SLOUGH ALLOTMENT FEDERATION

M4 J3-12 – MYRKE ALLOTMENTS

UNIQUE REF NO: M4312-S57045

Drawing title
WORKS PLANS
REGULATION 4 (2) (e)
SHEET 23 OF 31
MYRKE

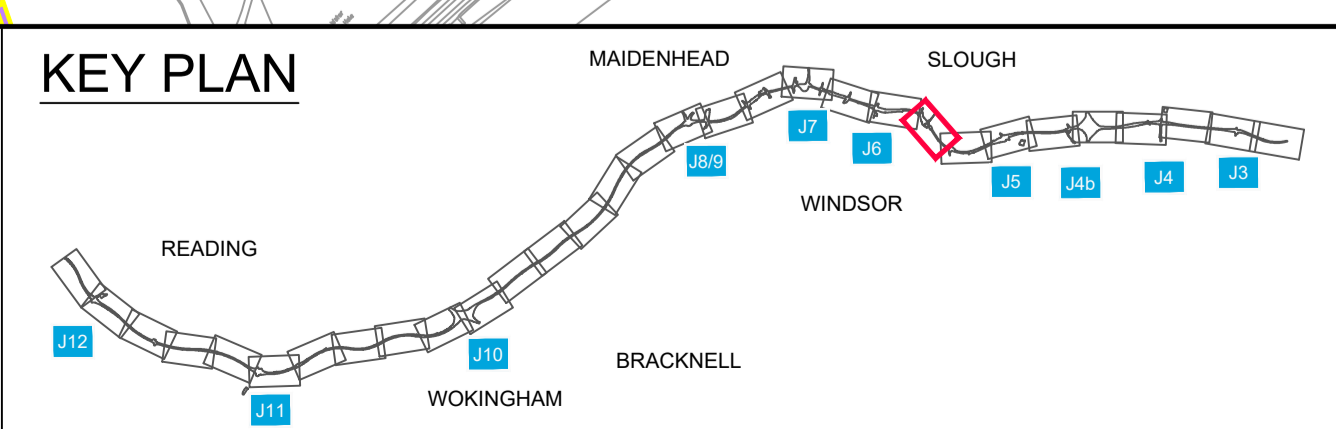
Highways England have confirmed by email 30th October 2015 from Chris Tooth, Mouchel PM that the planned area to be taken over has been reduced to c.1/3 of the original area, specifically 5 plots numbered 25-29. Part of plots 25 and 29 will be excluded. We very much welcome this development and will seek compensation for affected tenants through the DVS.

We seek clarification on how the plots will be returned. Allotment holders spend a considerable amount of time improving their soil structure. It was indicated at the Site Inspection Meeting that topsoil from the plots will be scraped back and held within the compound area during the works and then replaced before the plot is returned to the tenant. Please could this be confirmed.

Many tenants consider their allotment as a way of life and some spend many hours every day on their plot. The site is already a very noisy environment for all tenants but especially for the 60 with plots that directly border the motorway. Currently we have a standard fence and a thin strip of vegetation separating the allotments from the hard shoulder. There are currently no plans to upgrade this fencing.

We understand that the low-noise surfacing will help reduce noise however, it is our view that now the hard shoulder will become a lane of fast moving traffic, allotment tenants will experience a significant increase in noise disturbance.

In addition, part of the strip of vegetation will be permanently lost, forming the Emergency Refuge Area which will result in additional noise in that area. Other areas of vegetation will be removed for the works and replanted which until fully grown will also result in increased noise levels.

We would ask that consideration be given to erect a taller noise reducing boundary. This would also potentially improve air quality on the site which is an additional issue for growers.

We also seek reassurance on a safety issue - what will be in place to prevent vehicles breaking through the fence onto the allotment site in the event of an accident?

Access to the site for all vehicles - including HGV's – will be need to be maintained throughout the works apart from temporary short duration closures and we ask that these temporary closures are notified in advance to all tenants. It was mentioned during the site Inspection visit that this was agreed; please could this be confirmed.
